W/80/19/NMA

Application for a non-material amendment following a grant of planning permission. Town and Country Planning Act 1990

Proposed development of new Leisure Centre Facility (Use Class D2) and demolition of existing Leisure Centre Facility and Sports Dome, including modifications to the existing car parking arrangement, landscaping and associated works.

LU/314/16/PL

DRAWING
GA Site Plan

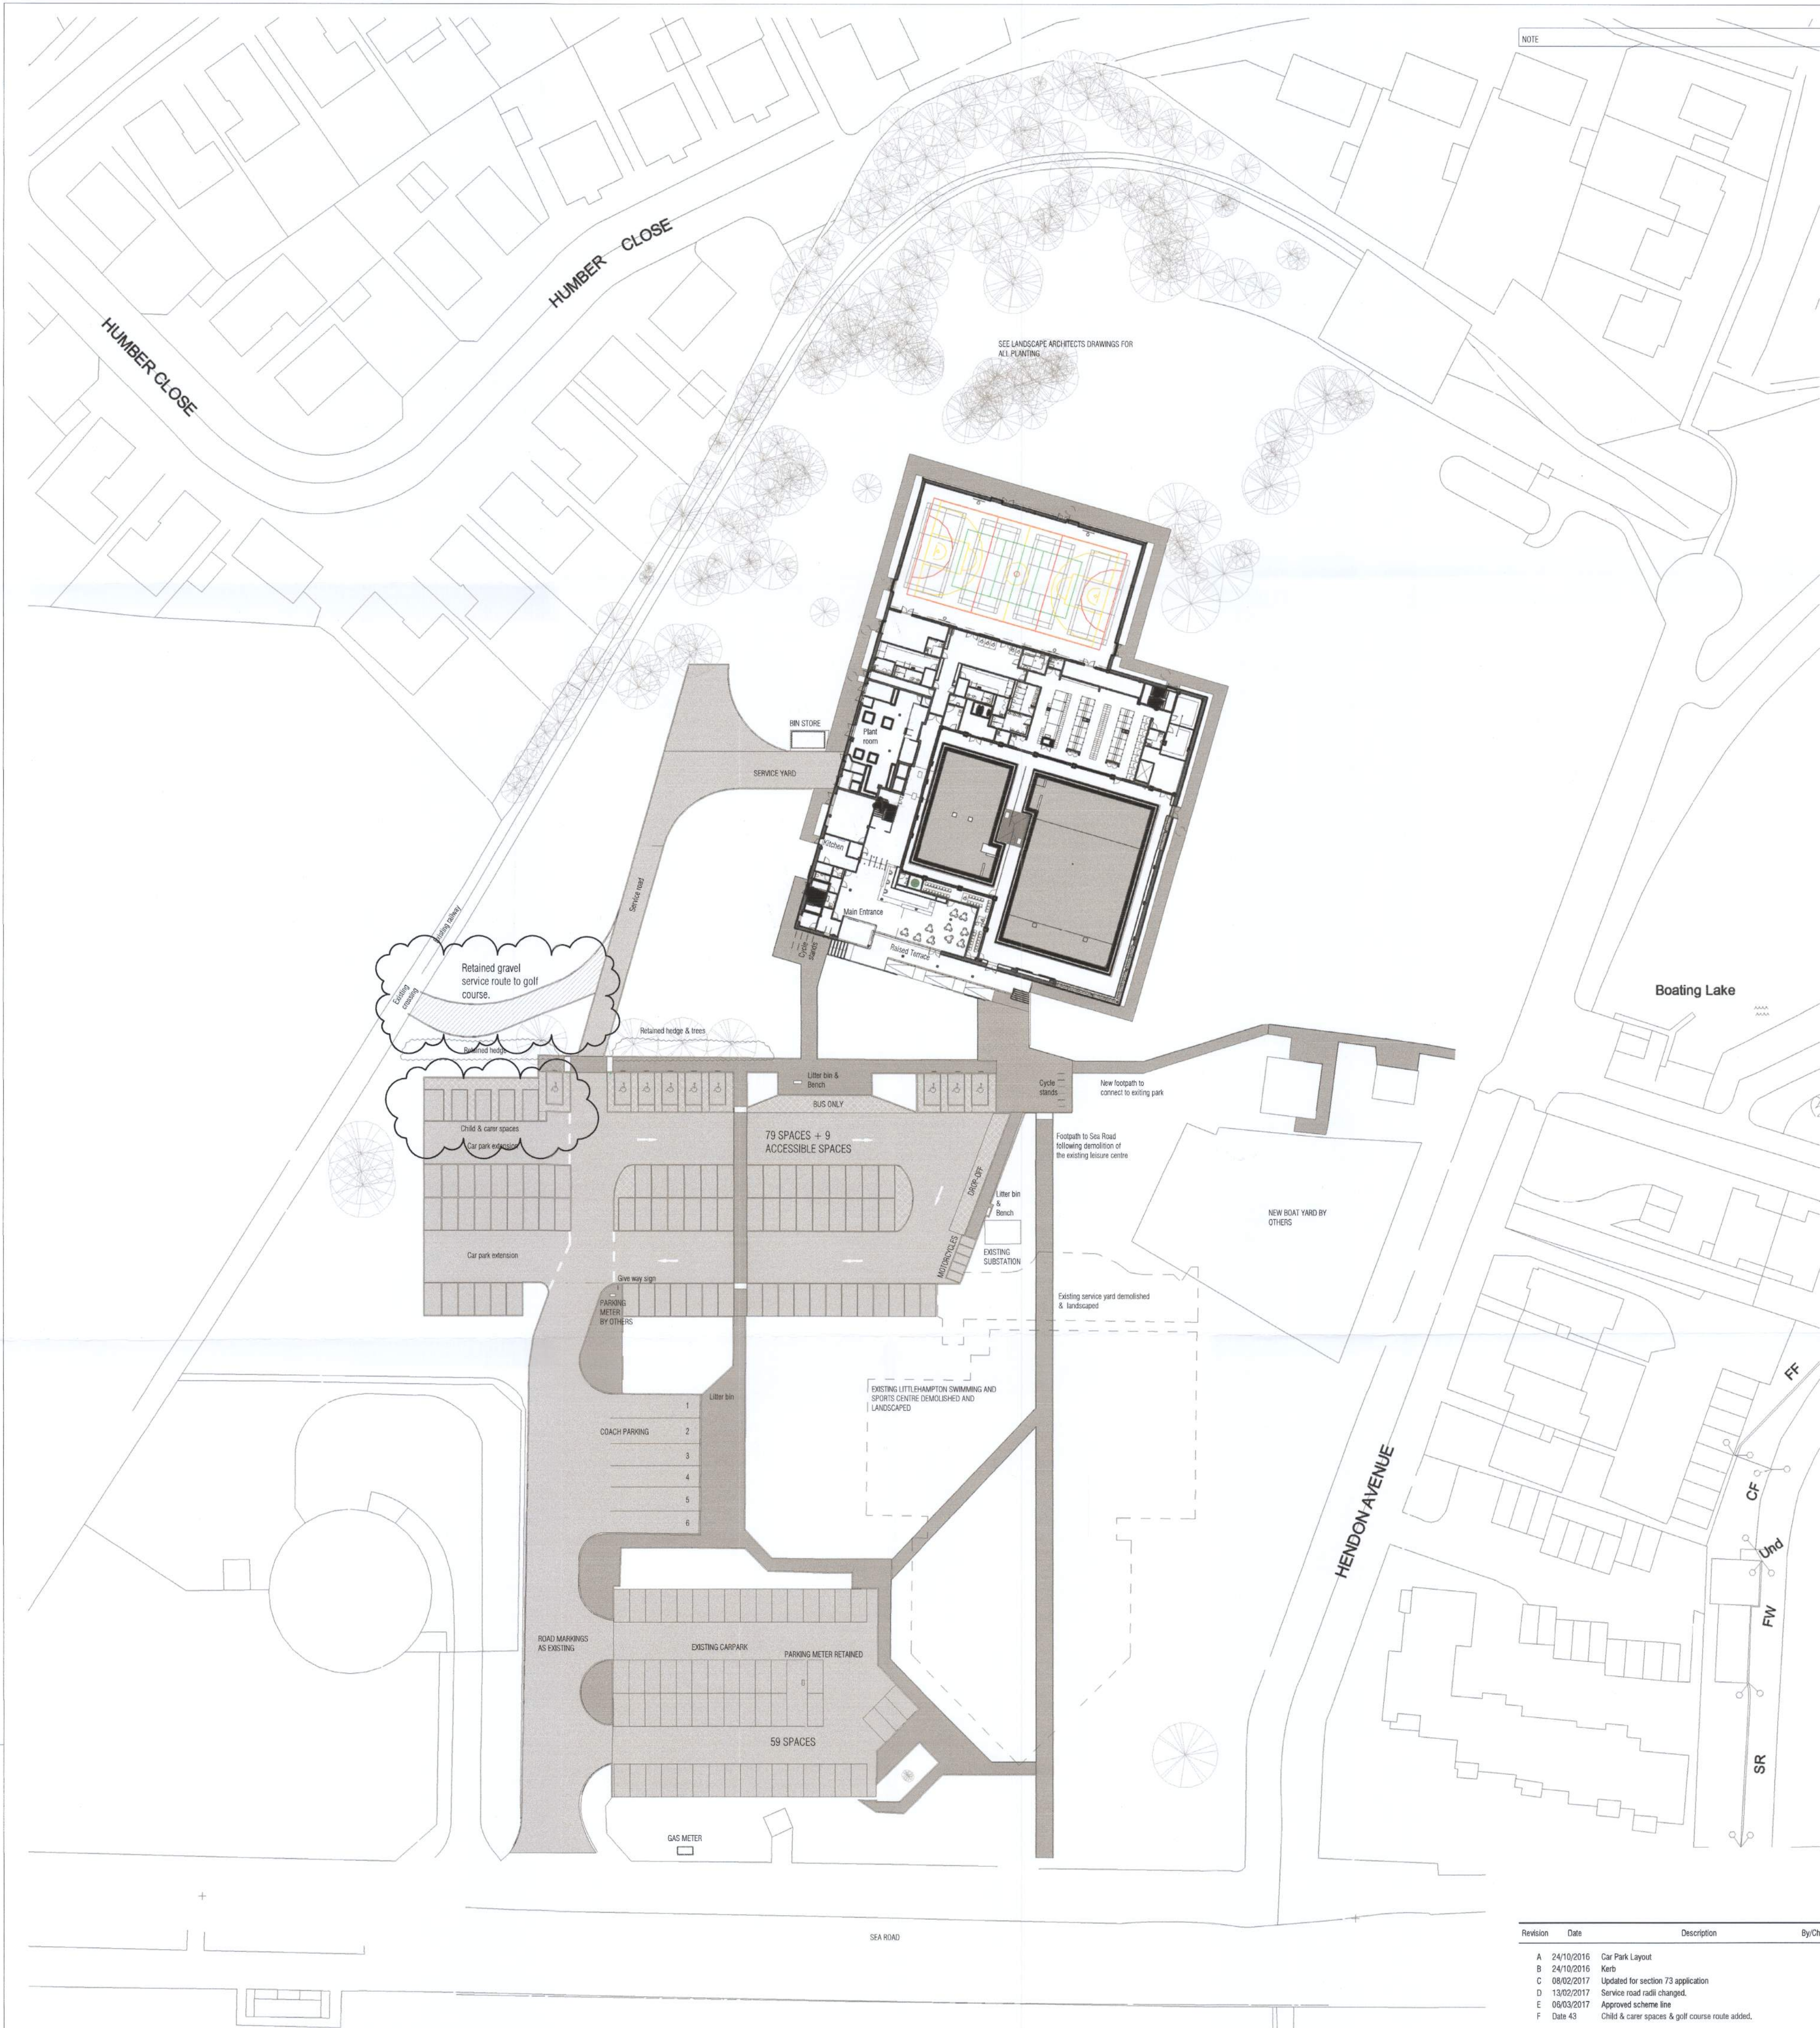
Provision of 5 No. controlled parking spaces for carers with children leading to a reduction of overall parking provision of 2 spaces.

Provision of a contained gravel access route from the new leisure centre service road to the existing railway crossing point to provide service access to the golf course. This will provide a fixed hard surface to a route that has been used by the Parks Department for some years, ensuring that vehicles follow a specific route and minimise any impact on adjacent soft planting.

Reuse existing light poles to car park and minimise new lighting to the service road.

The car park change is proposed to ensure visitors with young children can access their cars with greater ease and therefore for the centre to be most accessible to all sectors of the community.

The hard surface route will ensure vehicles follow this predetermined route for safe access in all weathers and reduce the impact on adjacent soft landscape (grass).

Re-use of existing light poles to reduce disruptive works in areas in use by the public and minimise the lighting to the service road to a level that provide for safe access and minimise light spillage as shown on accompanying drawing E531-M&R-V4-00-DR-E-0631 revision RD.
